**Change of use from (C3) dwelling to (D1) day nursery
Longacre Bungalow Maypole Lane Yapton**

Thank you for the information you have sent following my previous letter. Unfortunately I am still unable to accept the application as valid until the following matters are resolved:-

Block Plan 1-200 @ A1

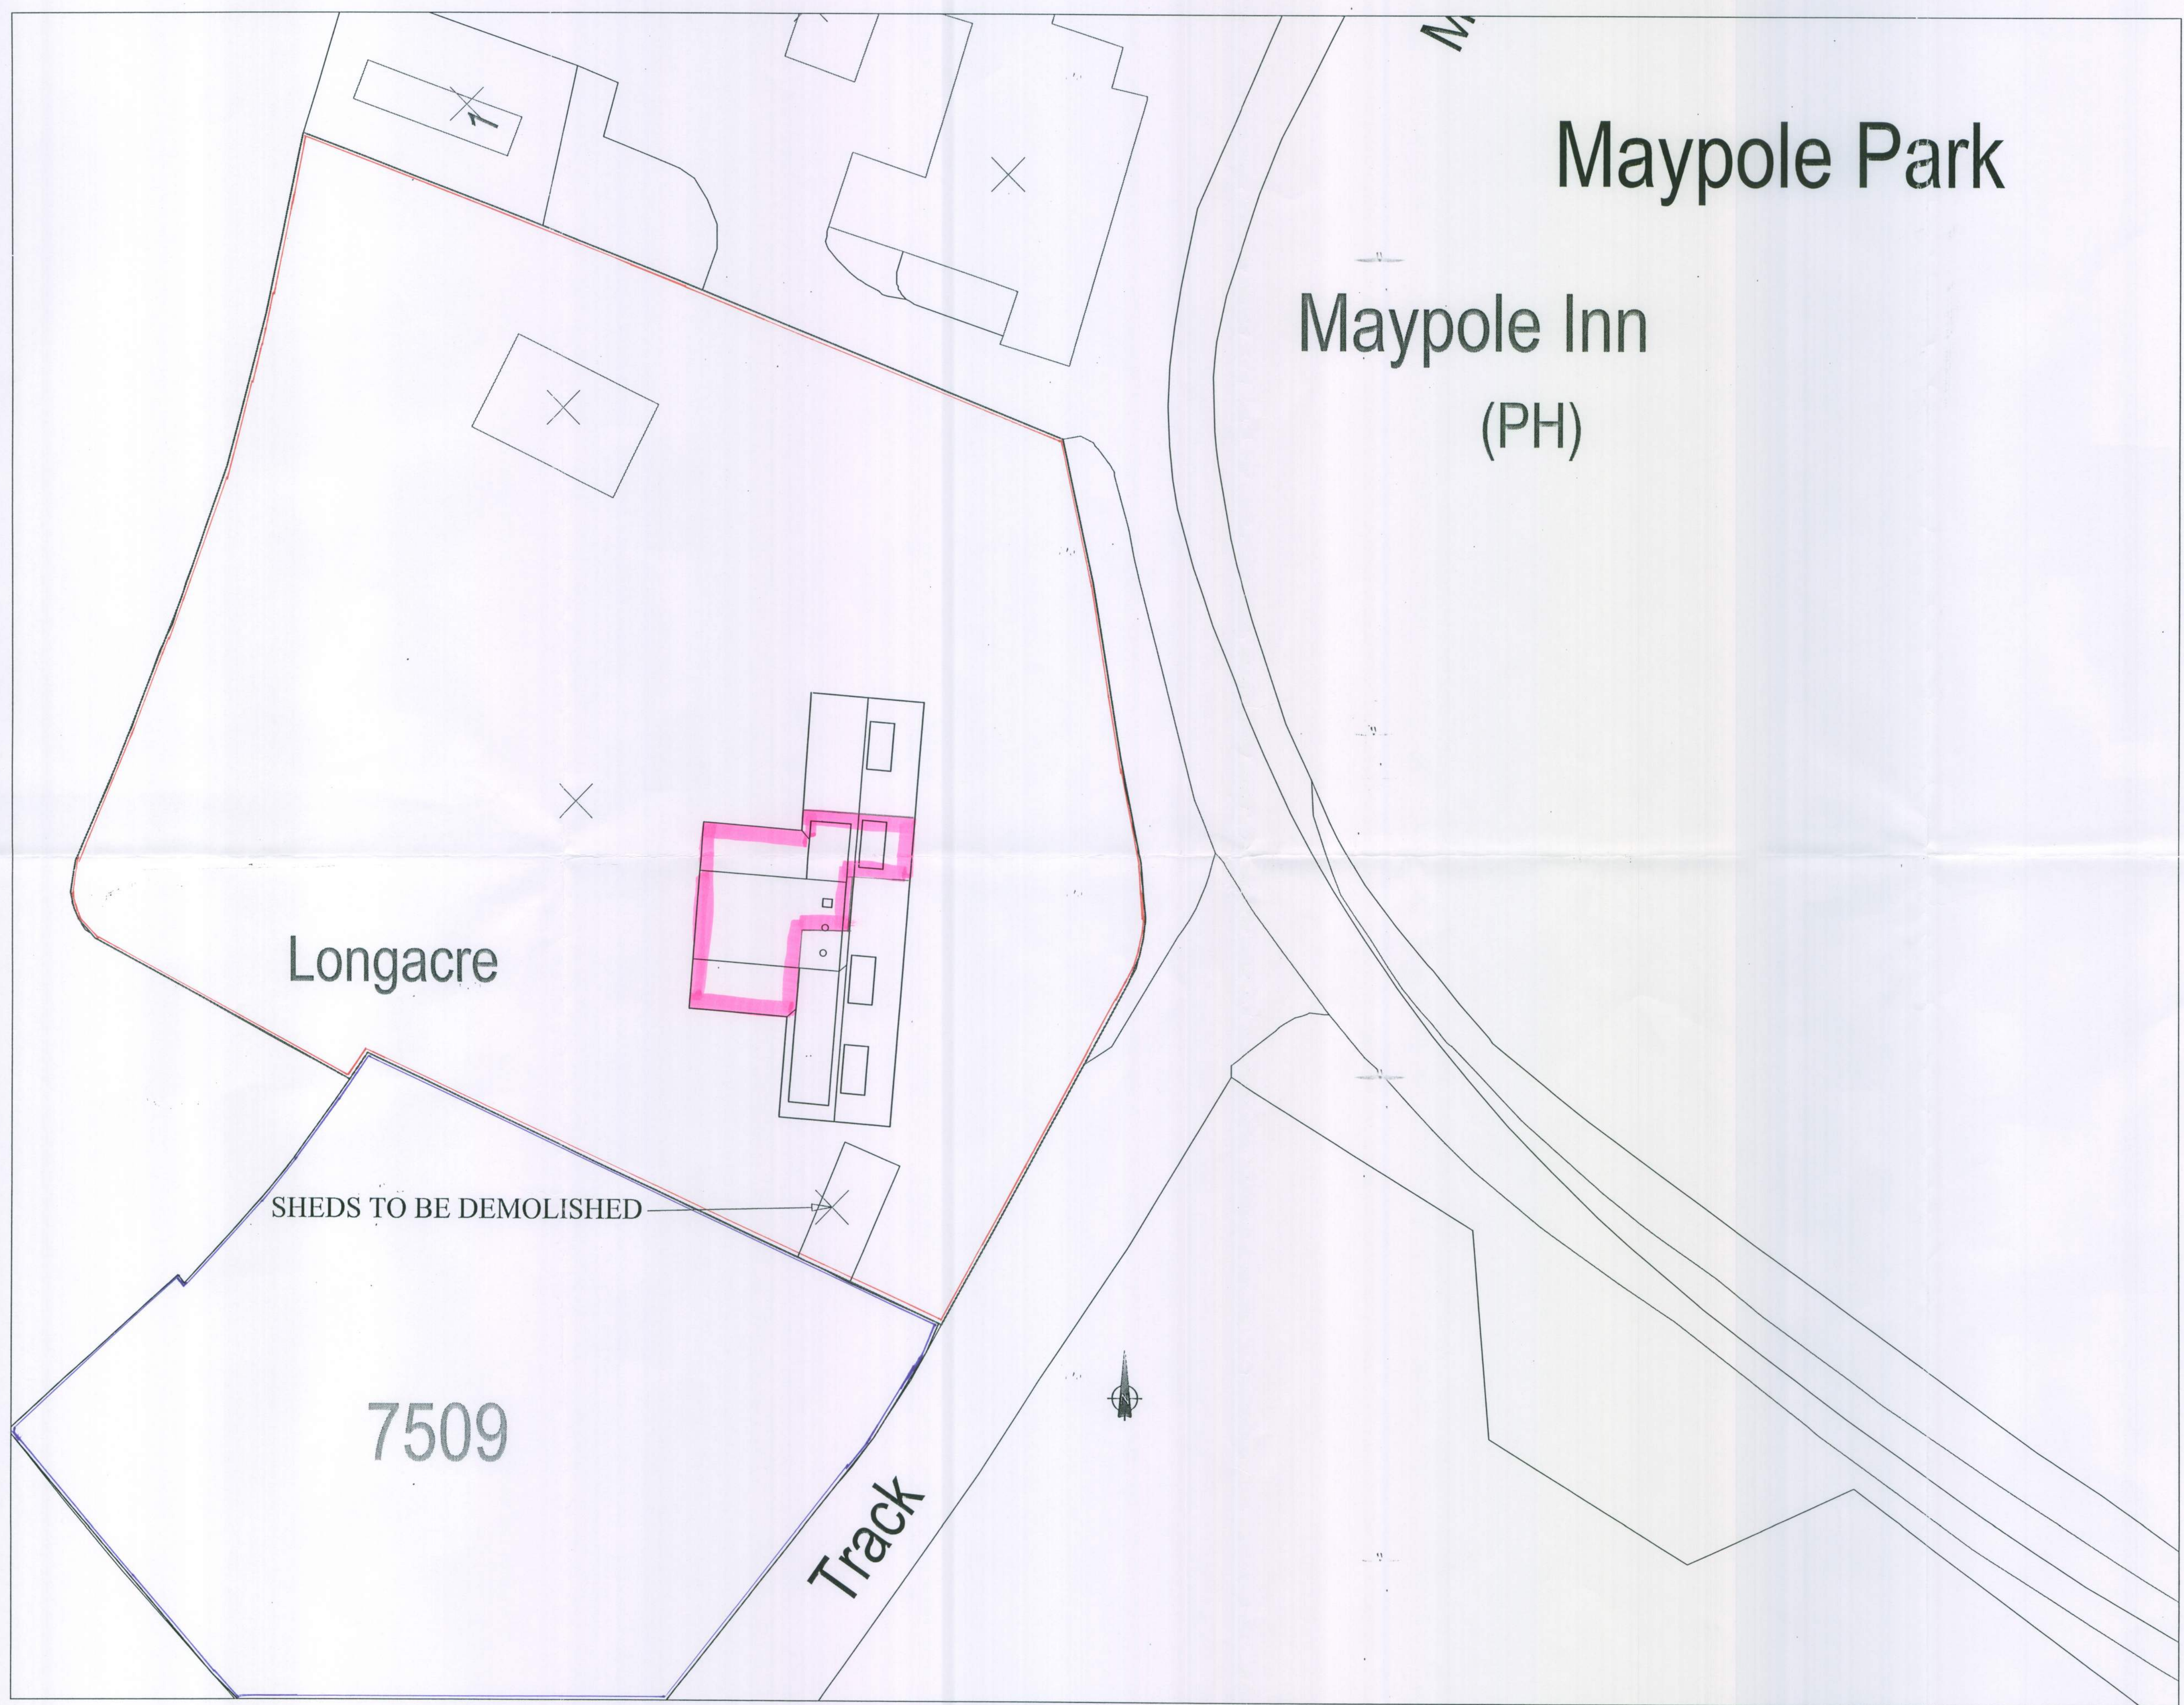
I require 1 electronic or 3 paper copies of a revised block/site plan showing the red and blue edging and the proposed works highlighted as per the previous plan, in accordance with the guidance notes available on our website detailed below (click on National List). X

Existing First Floor Plan

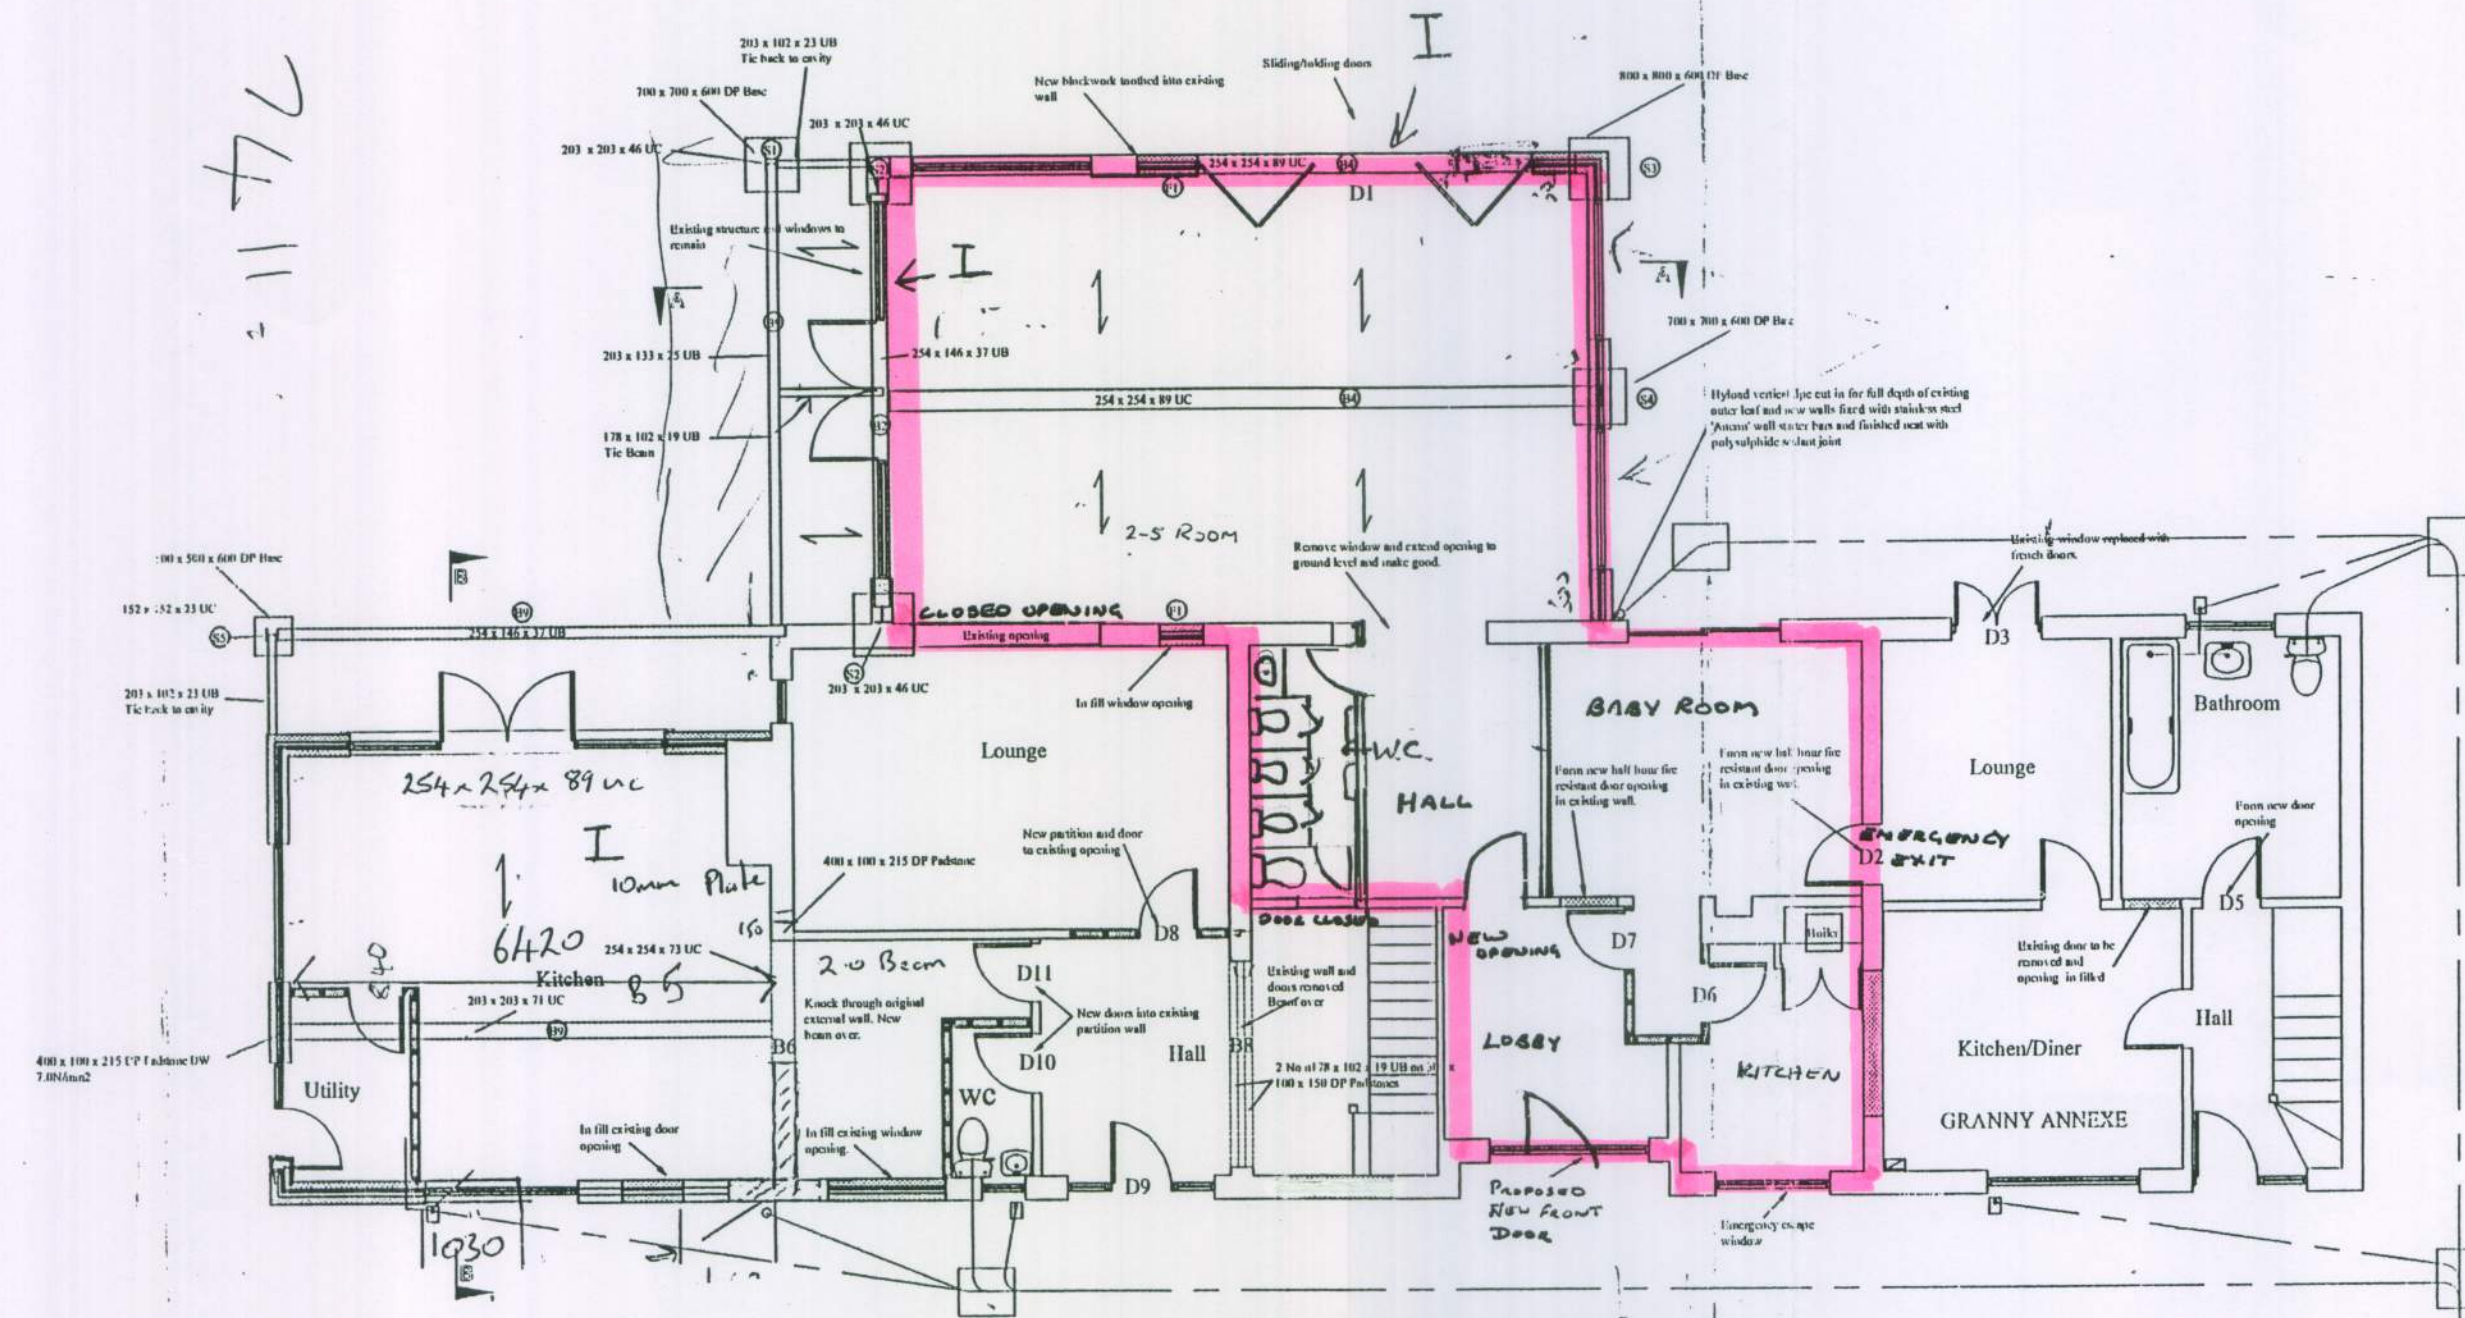
There are 3 rooflights shown on the existing west elevation which are not shown on the existing first floor plan. Please amend.

Proposed First Floor Plan

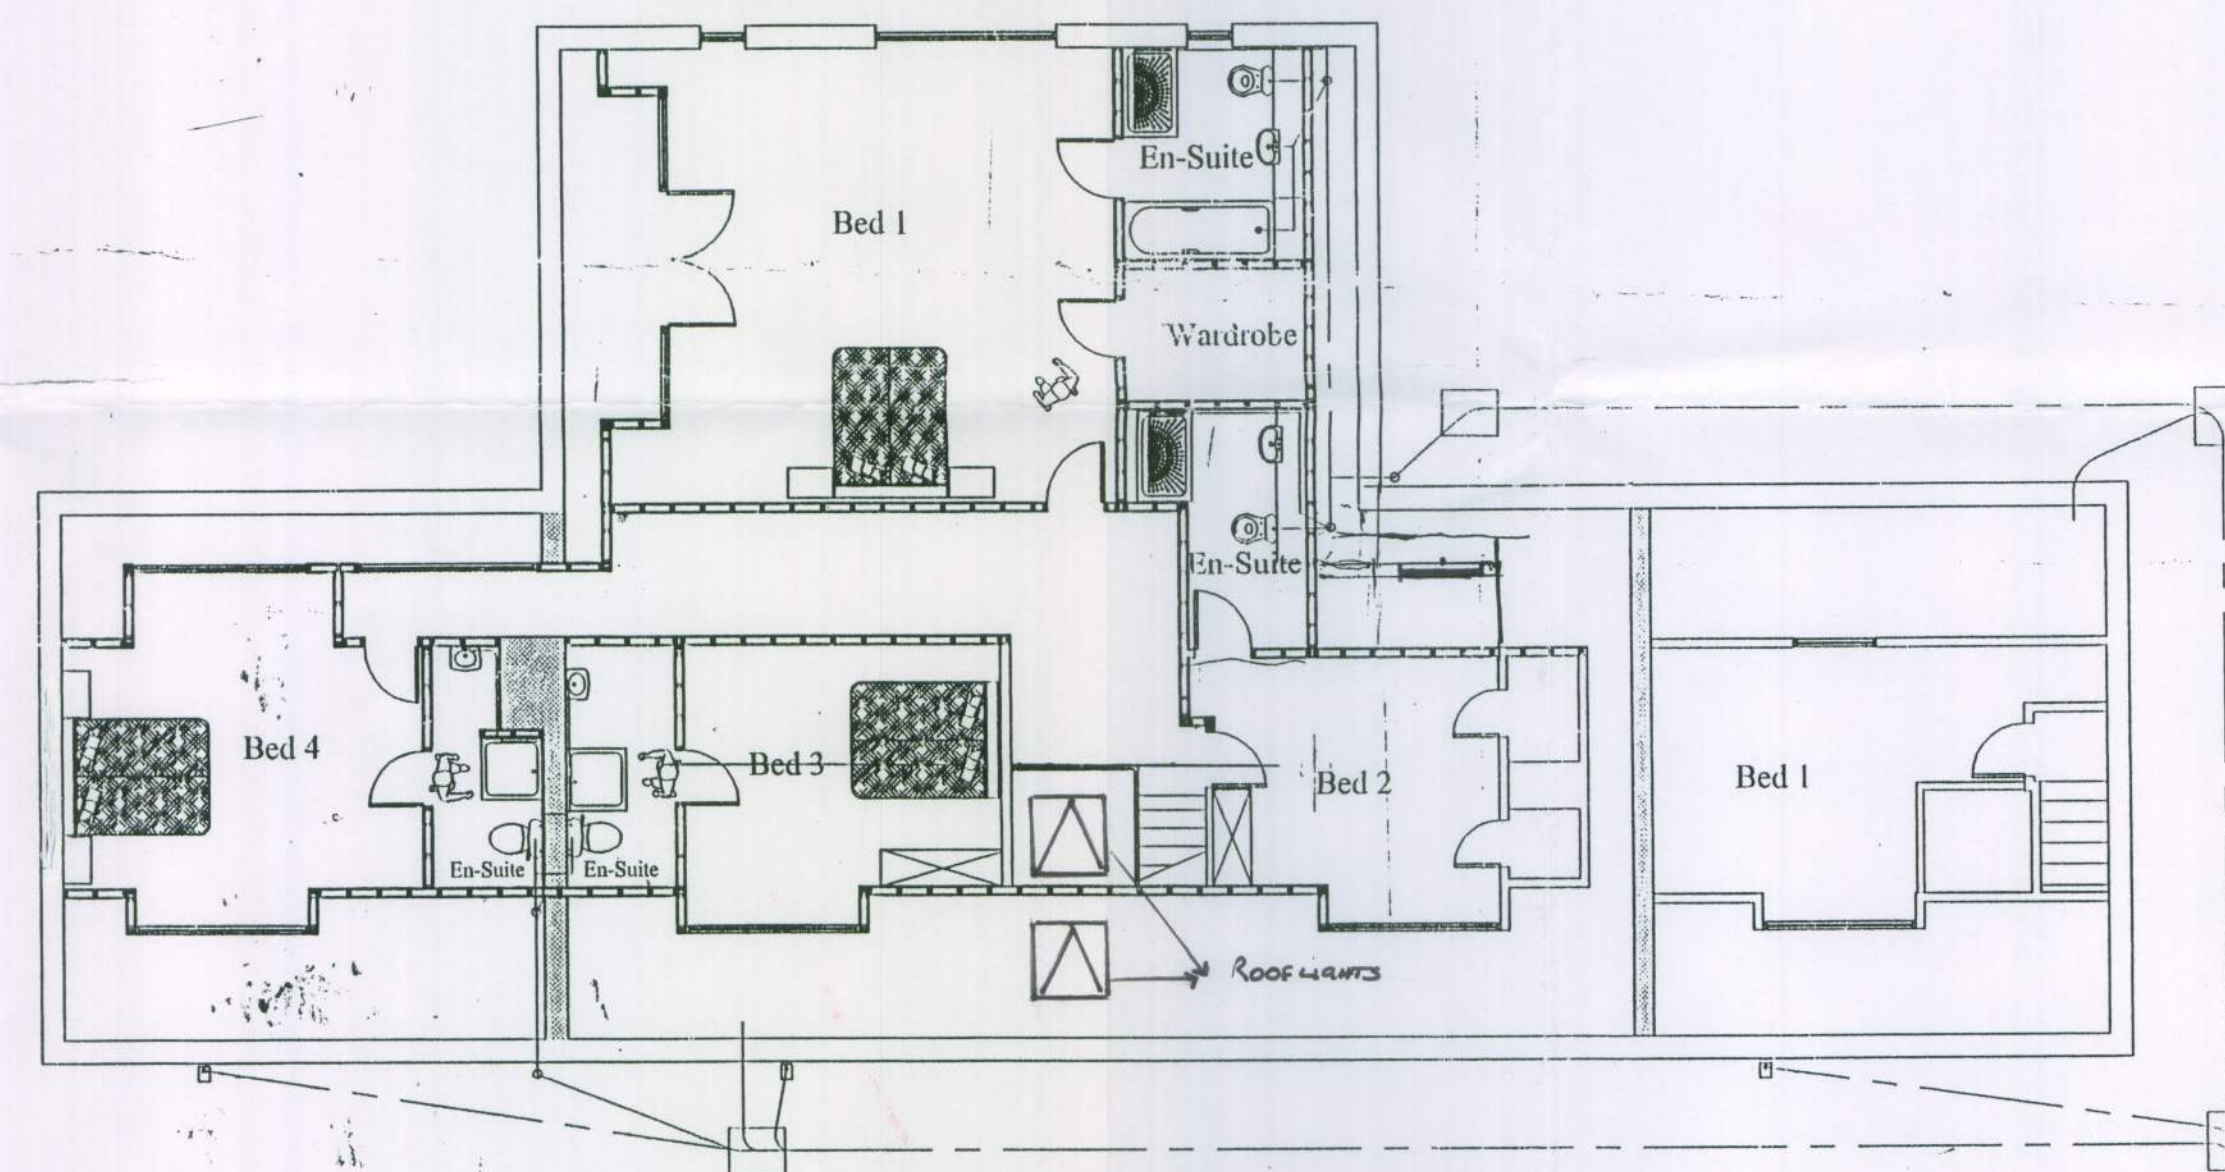
There is a window and a rooflight shown on the proposed west elevation which are not shown on the proposed first floor plan. Please amend.

Location Plan

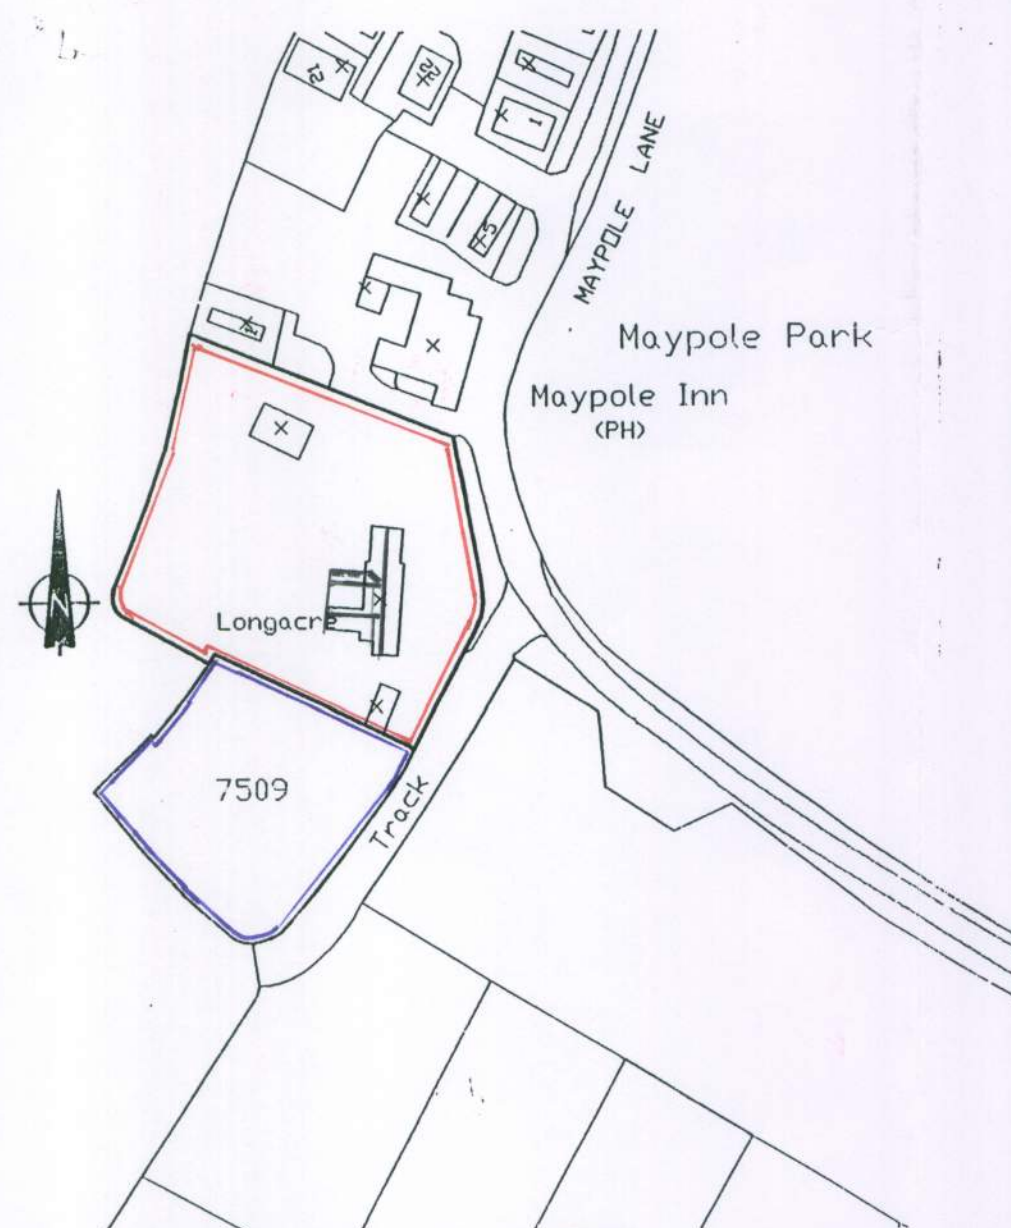
I require 1 electronic or 3 paper copies of a revised location plan showing the red and blue edging as per the previous plan, in accordance with the guidance notes available on our website detailed below (click on National List). ✓
